Conservation Officer – In response to consultation on original application stated: The main issue to be considered from a heritage perspective in the determination of this Listed Building Consent application is: -

The application seeks permission to alter some existing office spaces within Wentworth Castle (Northern College), within the Cutler Wing. The rooms were once bedrooms. The Cutler Wing is the earliest extant section of the house being built in 1670. The house and the wider landscape are listed grade 1 and of exceptional historic significance due to their architectural, historic and communal values. The rooms in question retain a good degree of historic detailing and mouldings including decorative architraves, cornice, friezes and fireplace surrounds. The decoration of the room intended to become teaching space C2 appears consistent with the late C17 date of the Cutler Wing. The room to become teaching room C3 is a little different in terms of its decoration and appears more classical, less floral and more restrained and may be a later alteration (of the decoration)

The proposal includes removal of existing modern partitions, reinstating the original form of the two forme

Prop Cutler House First Floor

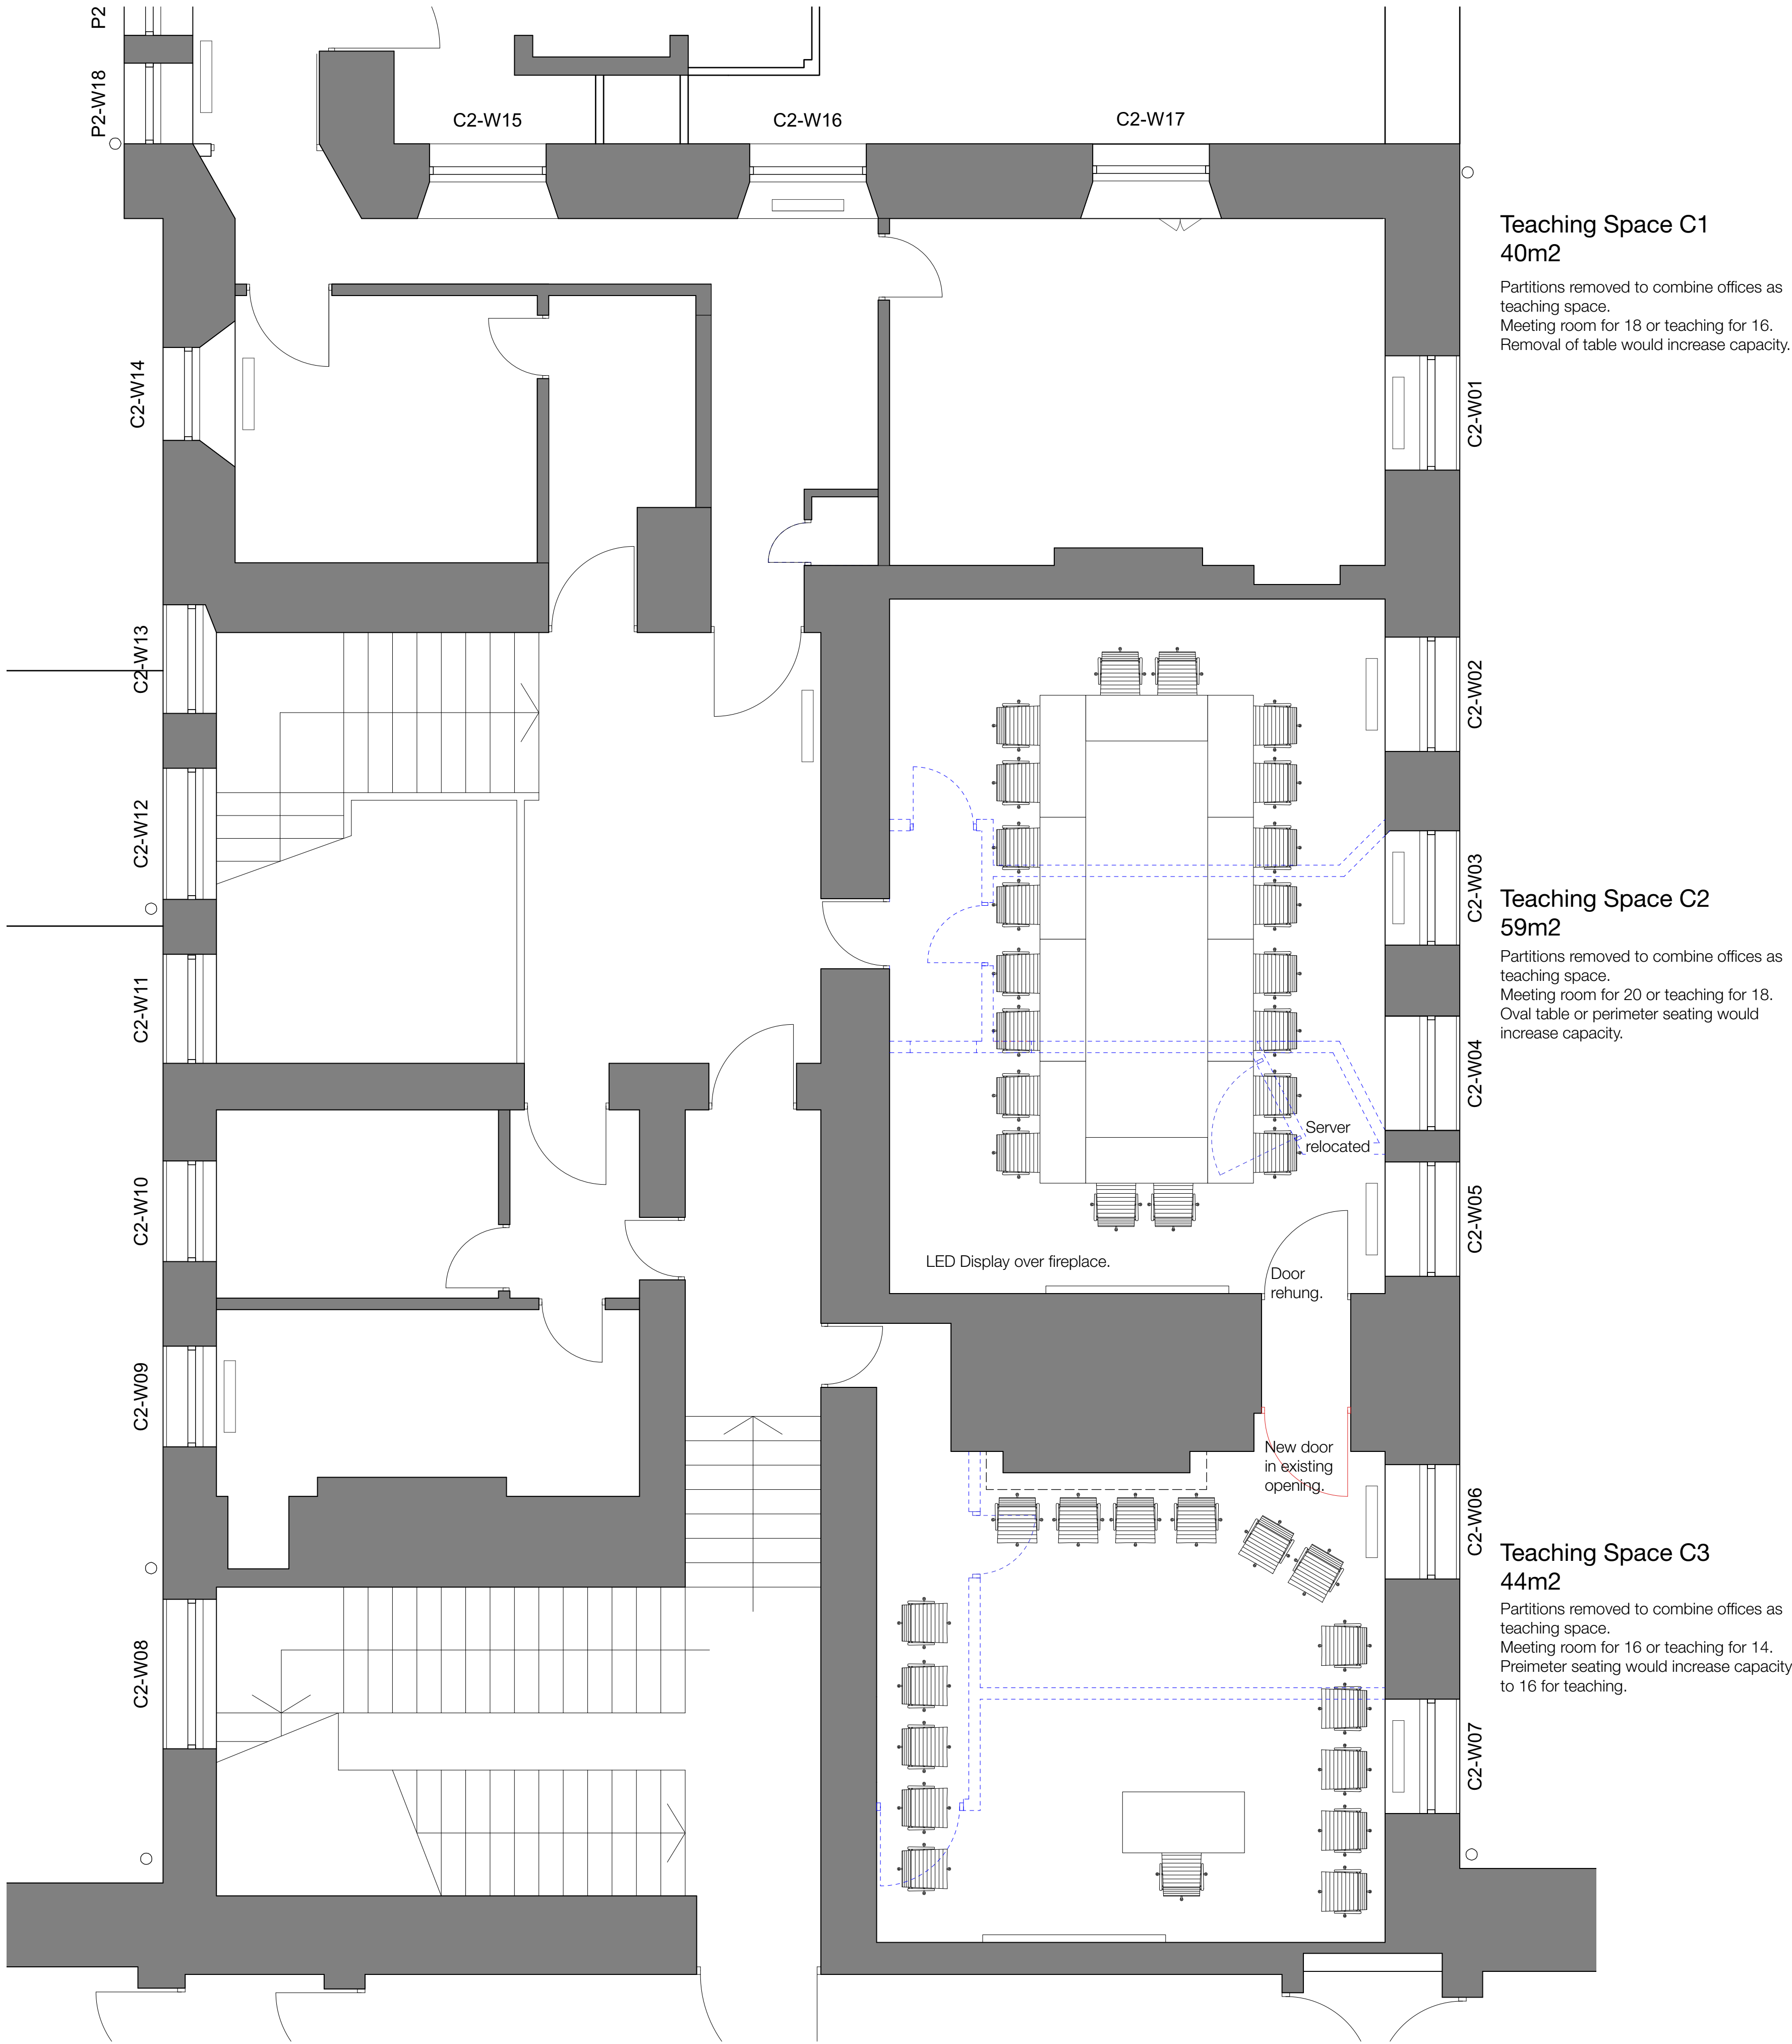
Currently the historic bedrooms are subdivided with modern (C20) lightweight partitions into five smaller rooms. It is clear that removal of these partitions will result in greatly improved legibility of the two historic bedrooms. The junctions between modern and historic fabric appear reversible with the modern partitions being scribed around the historic decoration and not cut directly into it. Whilst some making good will inevitably be needed, the works should be relatively straightforward. Consequently, the works will better reveal the heritage and significance of these spaces and overall be a clear net gain. Any areas of decoration damaged or uncovered in the process of the removal of the partitions will need to be made good and a condition is recommended accordingly.

The only minor concerns relate to the need to make good the areas where the modern partitions are removed and reveal any damage; a condition is recommended accordingly.
